**WEST SUSSEX COUNTY COUNCIL
PLANNING SERVICES CONSULTATION**

SUBJECT: BR/9/18/PL - Change of use of pavement to front area to accommodate 3 No. removable tables with chairs & cafe barriers. This application may affect the setting of a listed building.

Oceans, 13, High Street, Bognor Regis, PO21 1RJ

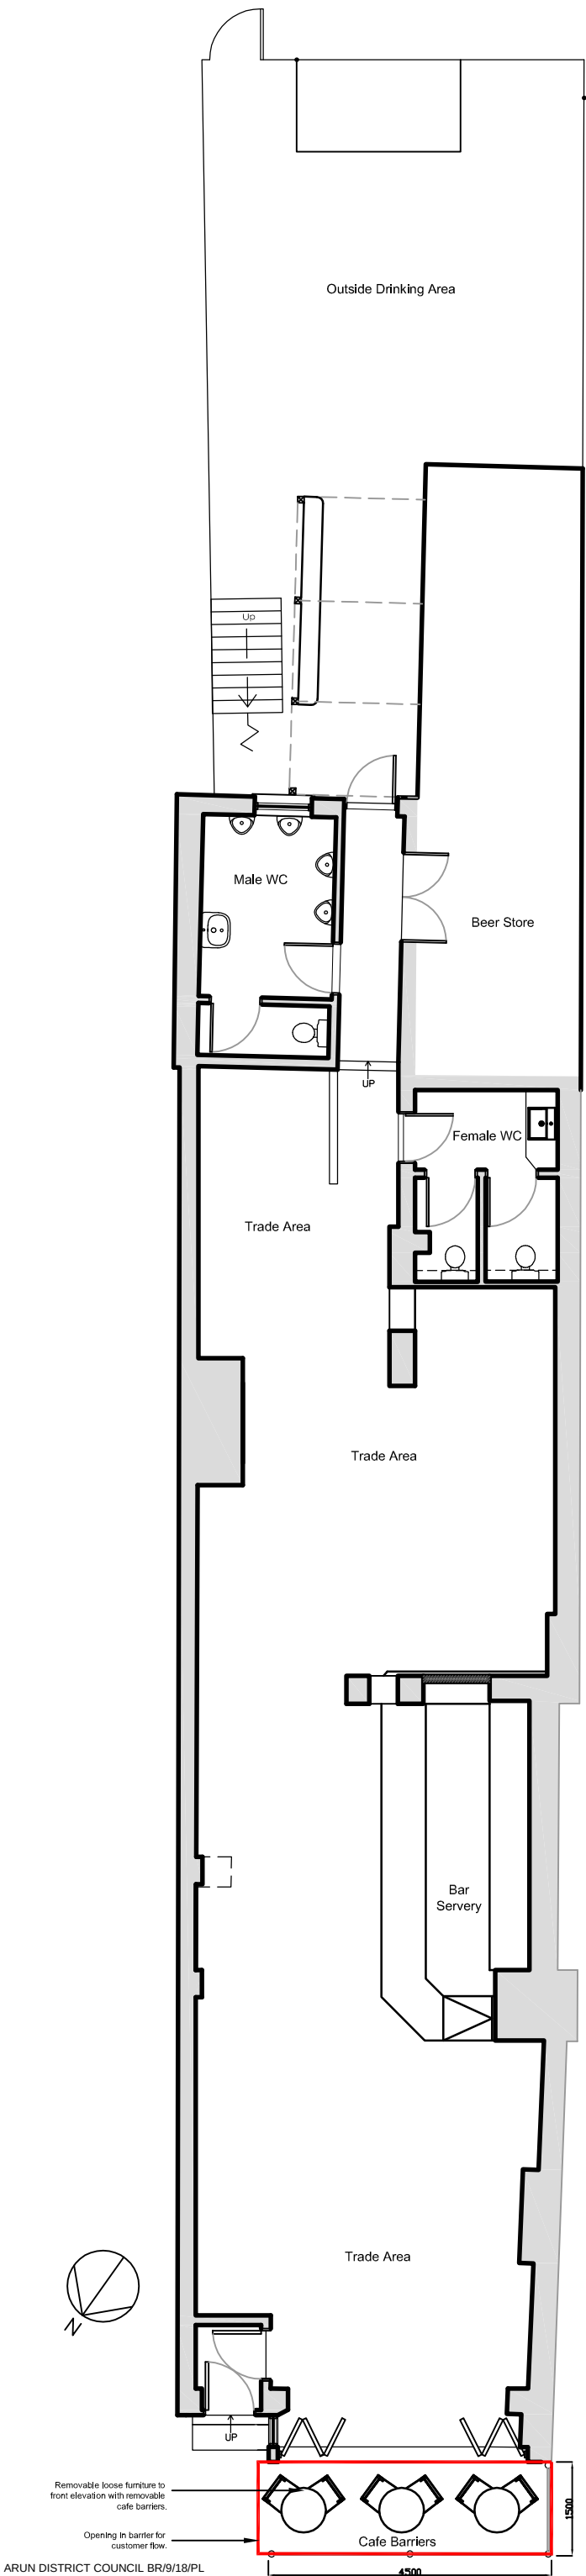
The proposal seeks approval for placement of 3 tables and 6 chairs with barrier on the footway outside no. 13 High Street. They will take up 1.5 m of footway width. Approximately 2.5m of footway width will remain between the proposed placement of the tables and the edge of the carriageway. High Street is 'C' classified and restricted to bus use only in this location. Manual for Streets (MfS) Figure 6.8 demonstrates minimum footway widths where 2m is advised and 2.5m where there is space to stay and chat. Whilst there appears to be sufficient remaining space the Local Highway Authority (LHA) cannot be certain that the existing street furniture (benches) are in such a position where suitable space would remain between the barrier of the tables and chairs area and the existing street furniture. Therefore we request that an additional plan is provided marking the location of the street furniture in the vicinity to scale so that the LHA can assess whether sufficient width remains for the pedestrian through route.

Please ask the applicant for this additional information and re-consult.
